WEST SUSSEX COUNTY COUNCIL CONSULTATION

TO:	Arun District Council FAO: Mrs. A. Gardner
FROM:	Highways, WSCC – Tim Townsend
DATE:	25 th June 2018
LOCATION:	Blastreat Limited & adjacent Greenhurst, Fitzalan Road, Arundel, BN18 9JS
SUBJECT:	AB/36/18/PL Demolition of existing buildings and erection of a block of 46 No. sheltered apartments for the elderly (comprising 22 x one bedroom apartments and 24 x two bedroom apartments age restricted to 60 years and over), with associated access, electric buggy/cycle stores and refuse bin store and 32 No. parking spaces. Re-submission of AB/77/17/PL.
DATE OF SITE VISIT:	20 th June 2018
RECOMMENDATION:	☒ Advice ☐ Objection ☐ Modification ☐ No Objection ☒ More Information ☐ Refusal
S106 CONTRIBUTION TOTAL:	£TBA

This is the WSCC Highways and Transport (CHA) response to the above planning application for Demolition of existing buildings and erection of a block of 46 No. sheltered apartments for the elderly (comprising 22 x one bedroom apartments and 24 x two bedroom apartments age restricted to 60 years and over), with associated access, electric buggy/cycle stores and refuse bin store and 32 No. parking spaces.

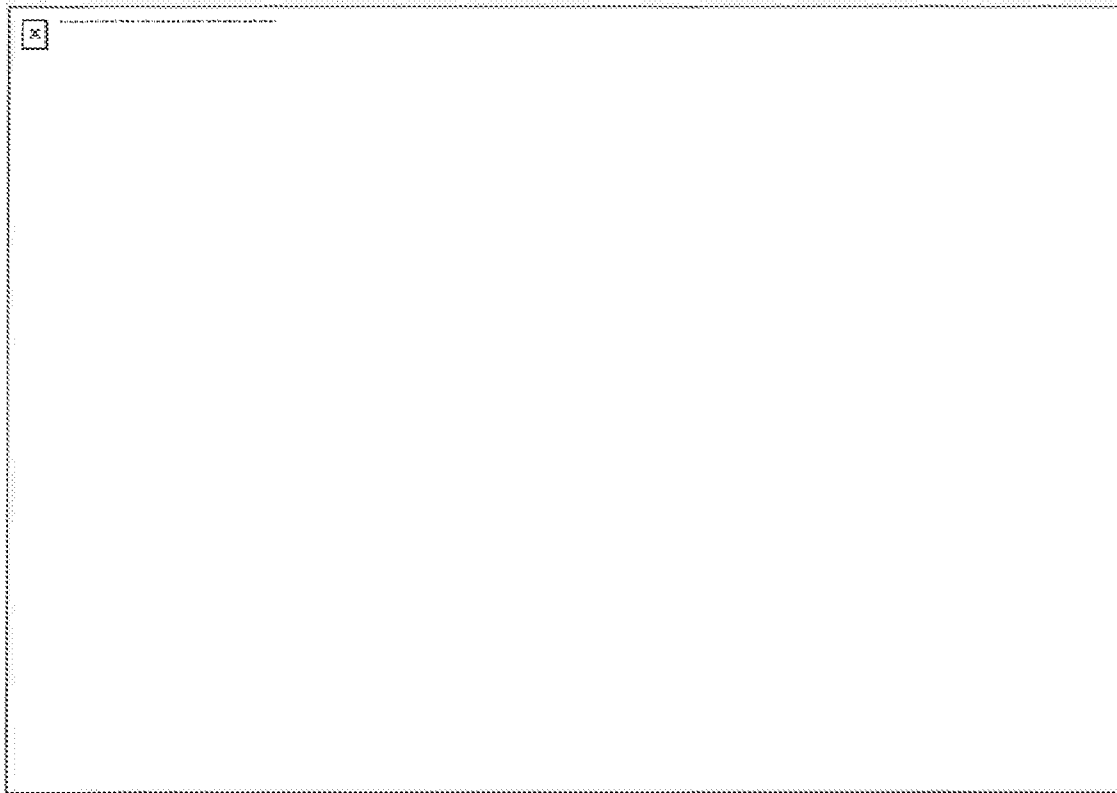
3. Information about future use of land along eastern flank and north-eastern flank of building and plan showing highway boundary overlaid on development plan.
